Application No: FP/1/25/HH

Site Address: 2 Leverton Avenue Felpham PO22 7RA

Description of works: Retrospective application for erection of a side boundary fence.

updated block plan

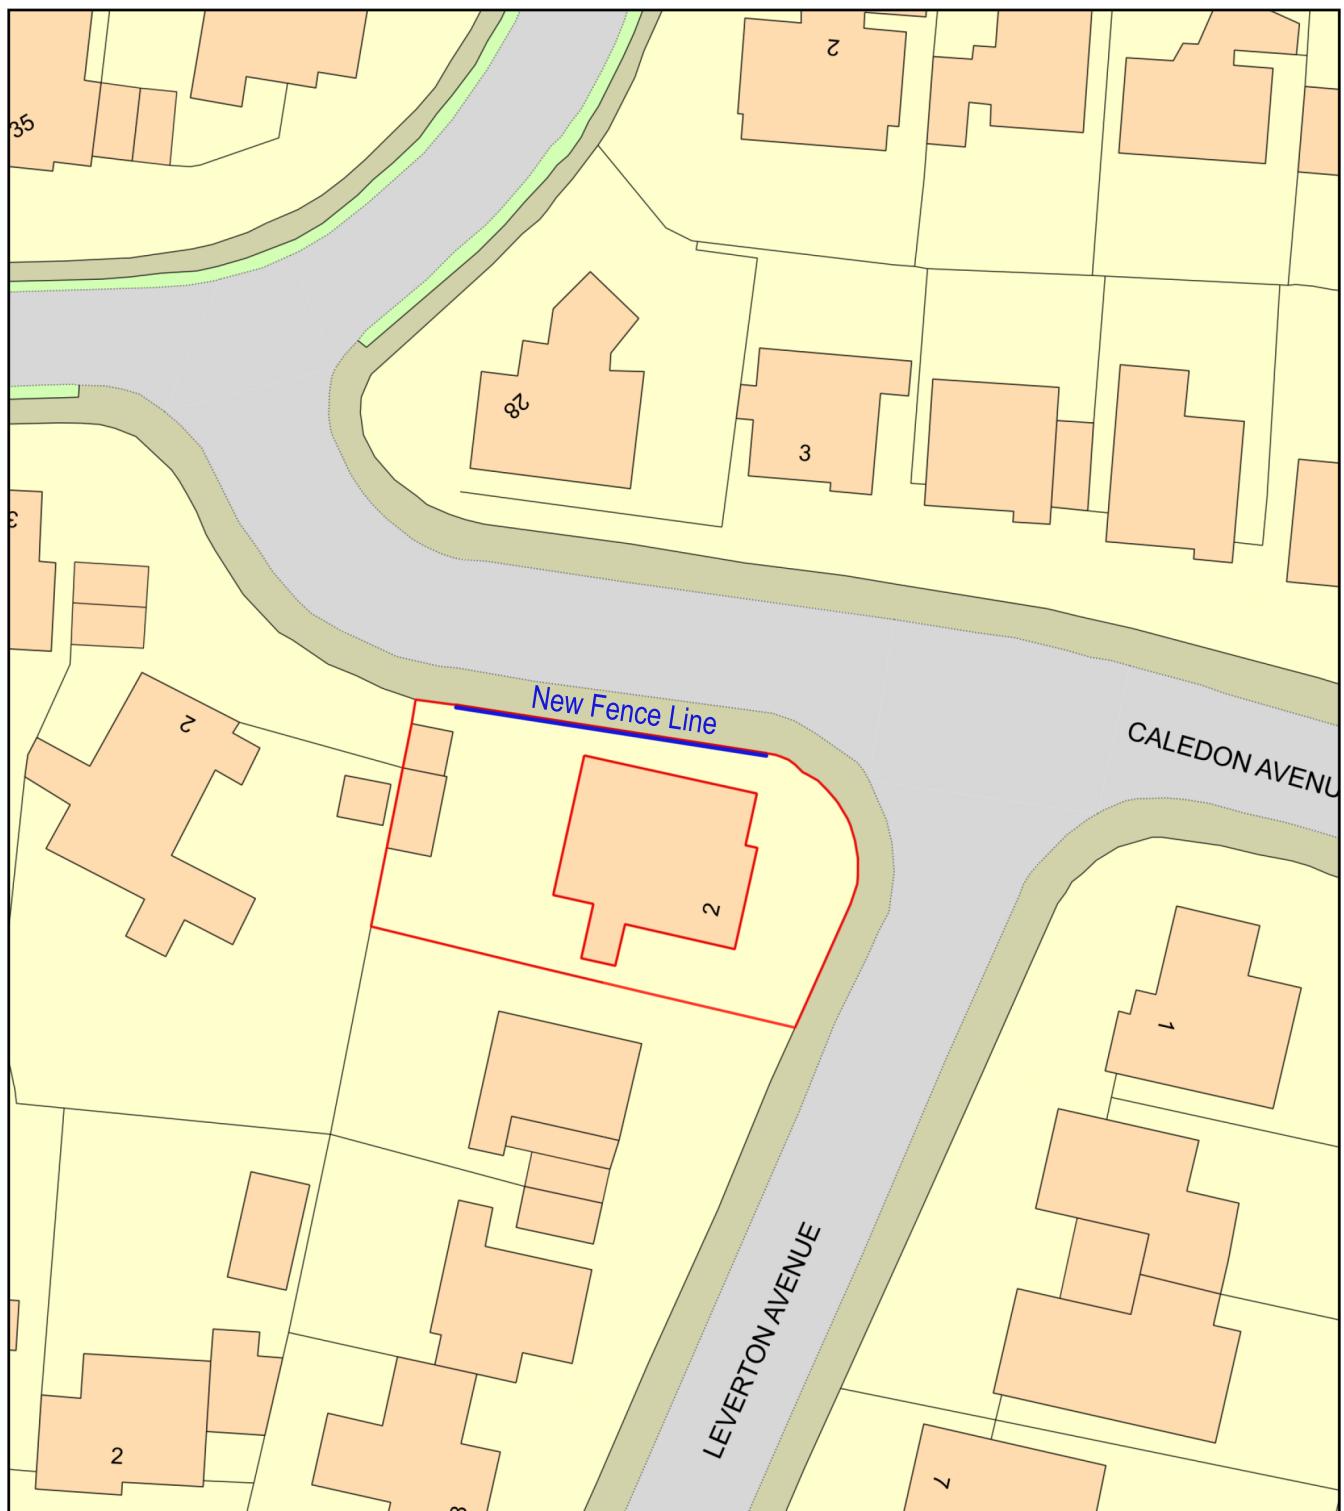
The erection of the fence and gate are too close to the pavement and are incongruous with the rest of the estate. The residents park their car close to the junction and this has resulted in dangerous driving conditions when navigating into Caledon Avenue.
